SSD 17_8373

ALEXANDRIA PARK

RESPONSE TO

3 OCTOBER 2018
SA6700
REVISED FINAL
PREPARED FOR NSW DEPARTMENT OF EDUCATION

C 5002_3PM WINTER SOLSTICE
1 : 1500

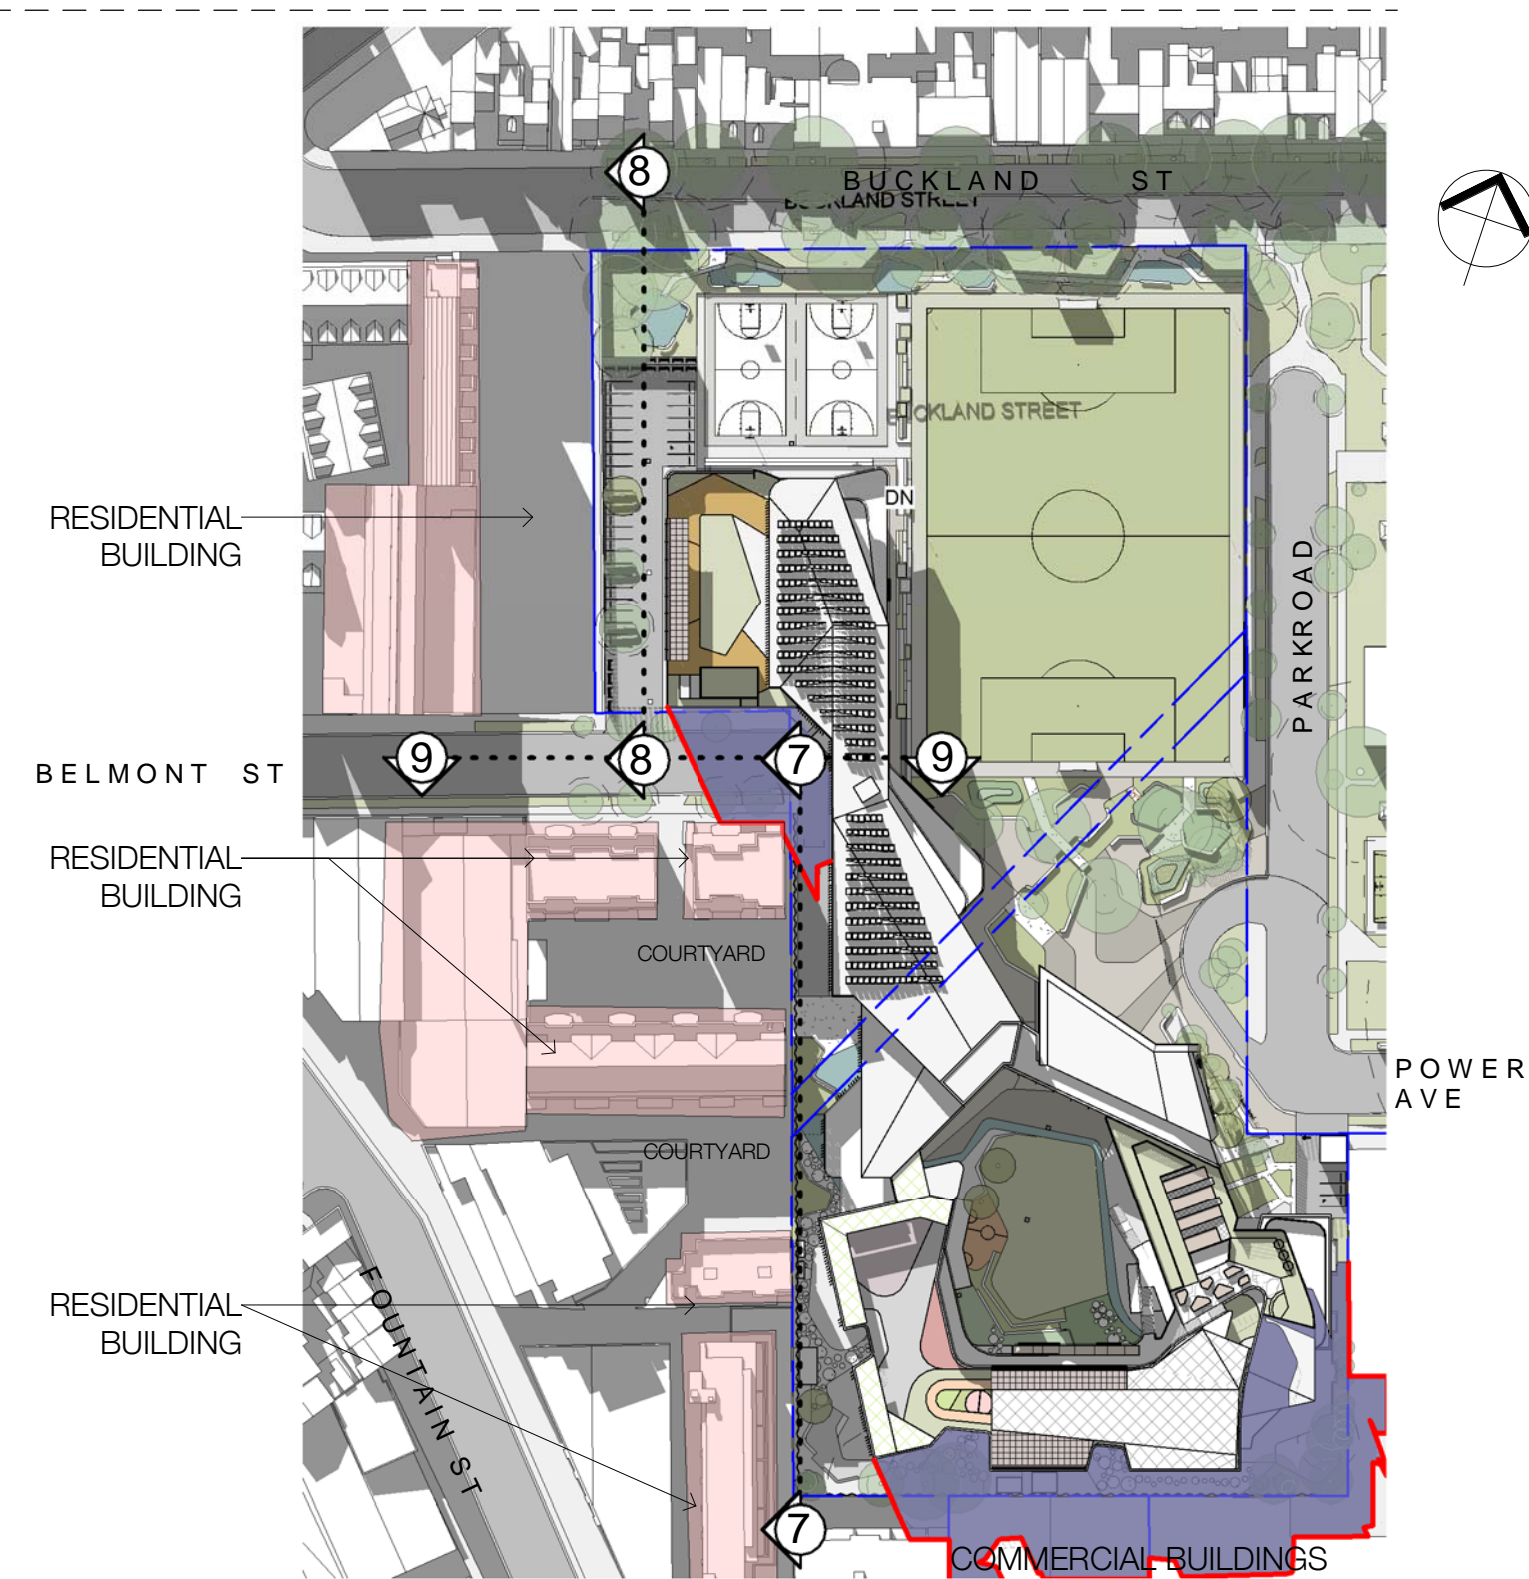
4. Overshadowing	<ul style="list-style-type: none"> The Department notes the comments of the Council regarding overshadowing. Section 6.2.3 of the EIS and Drawing Nos AR.DA.5001 and AR.DA.5002 do not adequately address or depict the shadow impacts of the proposed development upon adjacent properties. 	Refer to the updated Architectural Plans and Urban Design Report at Appendix B and Appendix D respectively for detailed shadow analysis, which is described in Section 3.1 of this RtS report.	Section 3.1, Appendix B and Appendix D

5. Overshadowing	<ul style="list-style-type: none"> A revised assessment of overshadowing impacts at hourly intervals between 9am and 3pm should be provided, including but not limited to: <ul style="list-style-type: none"> more detailed aerial plans detailing existing, height compliant and proposed shadow impacts; and more detailed elevations of affected properties depicting existing, height compliant and proposed shadow impacts and affected windows and room use. 	Refer to the updated Architectural Plans and Urban Design Report at Appendix B and Appendix D respectively for detailed shadow analysis, which is described in Section 3.1 of this RtS report.	Section 3.1, Appendix B and Appendix D

TKD have amended the proposal to improve solar access to 58-60 Belmont Street when compared to the original SSDA. Figure 3 illustrates by shifting the proposed hall 3m north, the Belmont Street building receives much more sun at 2pm in mid-winter. An hour-by-hour analysis of sun access to the northern facing apartments is detailed in Table 1. The table shows that Units 1, 2, 3, 17 and 18 will receive an additional 1-2 hours of sun with the amended proposal. Overall, all apartments will receive at least 2 hours of solar access in mid-winter. This is consistent with the Apartment Design Guide (ADG) and Sydney Development Control Plan 2012 (SDCP). The amended proposal is therefore an improvement and addresses community and agency submissions. This is discussed in more detail in Section 4 of this RtS.

TKD have modulated the primary school home bases to allow greater solar access to 141-143 in response to public submissions. The amended proposal achieves 2 hours of solar access between 9am and 3pm at mid-winter to 17 of the 18 north facing apartments. Unit 8 will receive 1.5 hours of solar access. This is an additional hour when compared to the original SSDA. On balance, the proposed shadow impact is not unreasonable. The amended proposal achieves 2 or more hours of solar access to 95% of north facing apartments, which complies with the ADG and SDCP. The proposal provides significant community and social infrastructure and, on balance, the amended design maintains appropriate level of amenity to adjoining properties.
